RE: SSD 8839 THE RIBBON IMAX FIT-OUT – RESPONSE TO REQUEST FOR FURTHER INFORMATION

This submission has been prepared by Ethos Urban on behalf of Grocon (Darling Harbour) Developments (Grocon), in response to the Request for Further Information (RFI) issued by the Department of Planning, Industry and Environment (DPIE) on 3 July 2019, relating to SSDA 8839. SSDA 8839 seeks approval for the fit-out and operation of the IMAX Cinema component of The Ribbon development, consistent with the use and base building previously approved under SSD 7388.

| PROJECT NUMBER A004409 | DRAWING NUMBER ARC-HSL-DD-1103 | | | REV M |

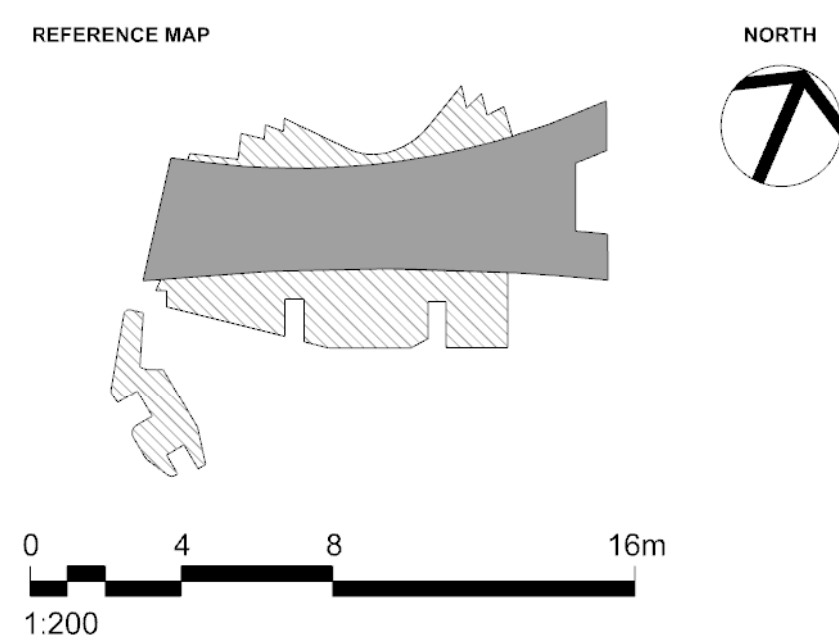
The RFI requested the submission of Architectural Plans for Level 3 and Level 4 of the development to confirm consistency with the SSDA 7388 approval as modified, specifically noting modifications as sought under SSDA 7388 MOD 8. We note that SSD 7388 MOD 8 sought to reconfigure the internal layout of the IMAX component to achieve consistency with SSD 8839. SSD 7388 MOD 8 has since been approved. Accordingly, the requested Architectural Plans are found in **Attachment A**. These plans show the projection room on Level 4 as noted in the RFI.

The RFI also identified inconsistencies between the Architectural Plans and the indicative fit-out plans, specifically with regards to the arrangement of seating within the cinema. In response to this inconsistency, we confirm that indicative fit-out plans show the seating arrangement as sought under this application. Seating arrangements as shown in the Architectural Plans are to be dismissed.
